Landscape Plan Drawings_V1.PDF Markup Summary

File:
FINAL LANDSCAPE PLAN
DUNKIN BENT GRASS
SITE DEVELOPMENT PLAN
LOT 1A, BENT GRASS EAST COMMERCIAL FILING NO. 2A,
LOCATED IN TOWN OF PEYTON,
COUNTY OF EL PASO, STATE OF COLORADO

LANDSCAPE DETAILS			Title:		
DUNKIN BENT GRASS SITE DEVELOPMENT PLAN LOT 1A, BENT GRASS EAST COMMERCIAL FILING NO. 2A, LOCATED IN TOWN OF PEYTON, COUNTY OF EL PASO, STATE OF COLORADO			WC Civil Team: TS, LP		
Date: 2/22/2032/22			Engineering No.:		
Scale: AS NOTED			Sheet No.:		
12

LANDSCAPE PLAN

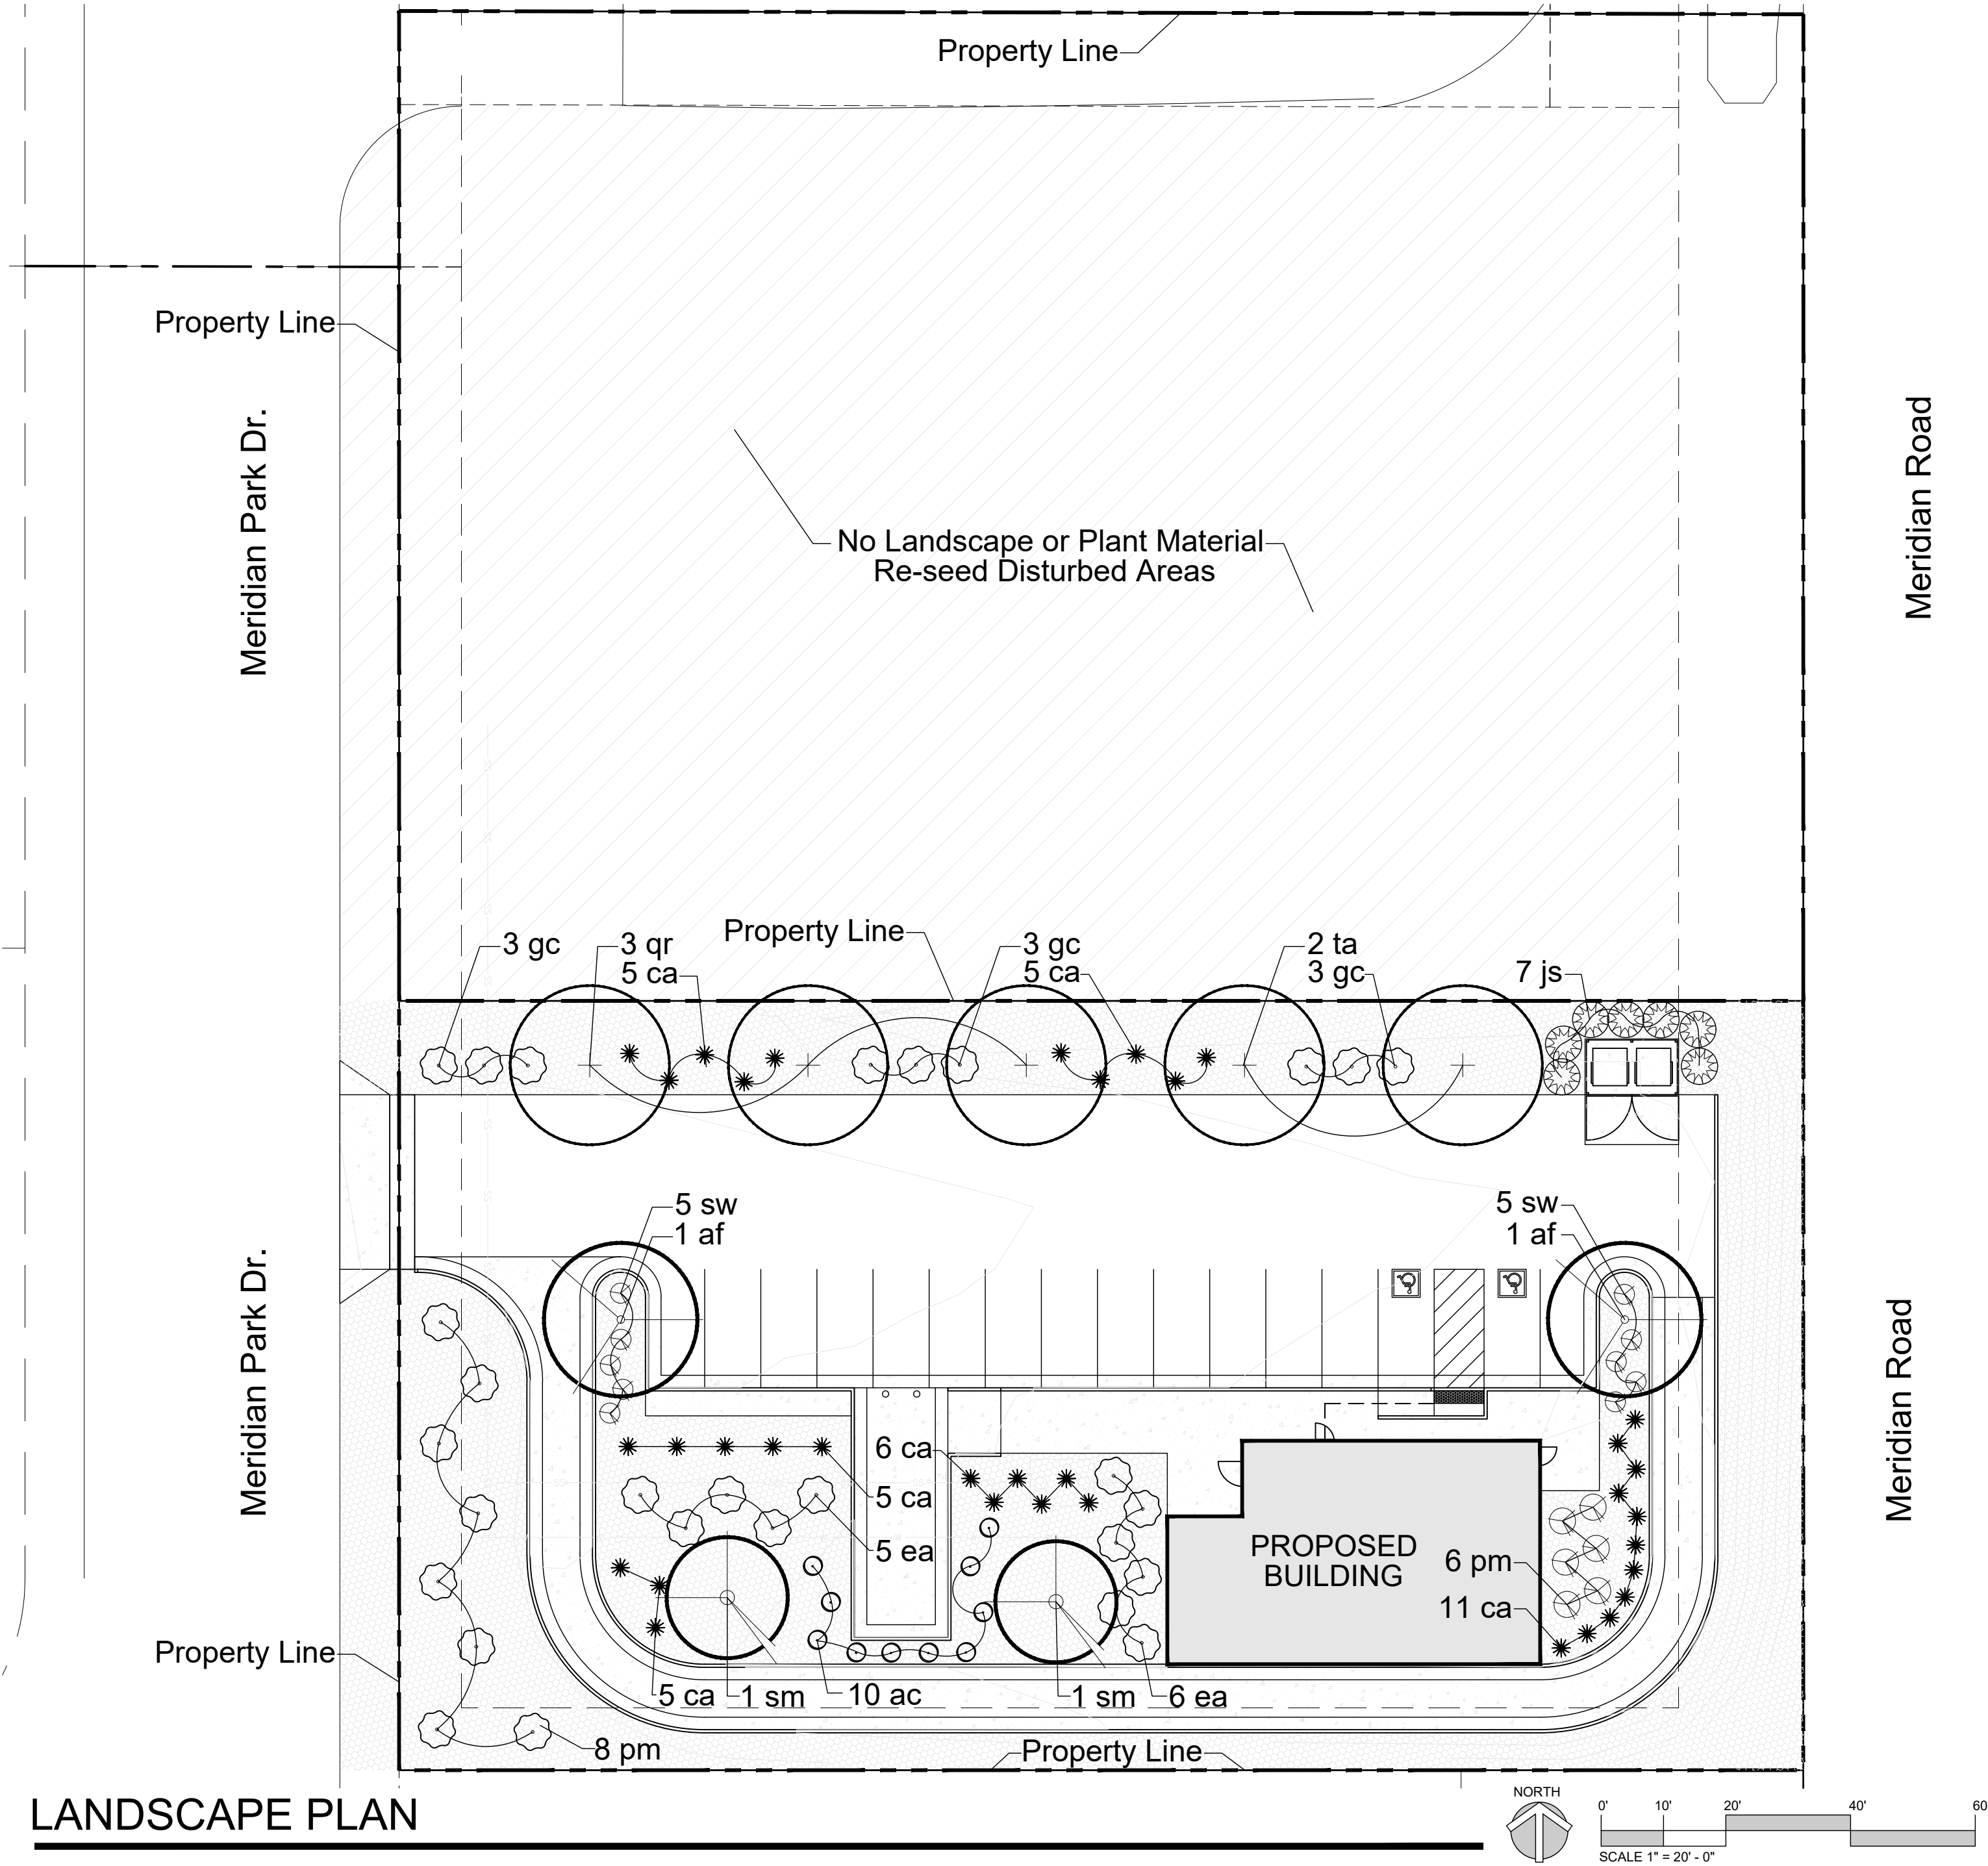
Correct to actual property line
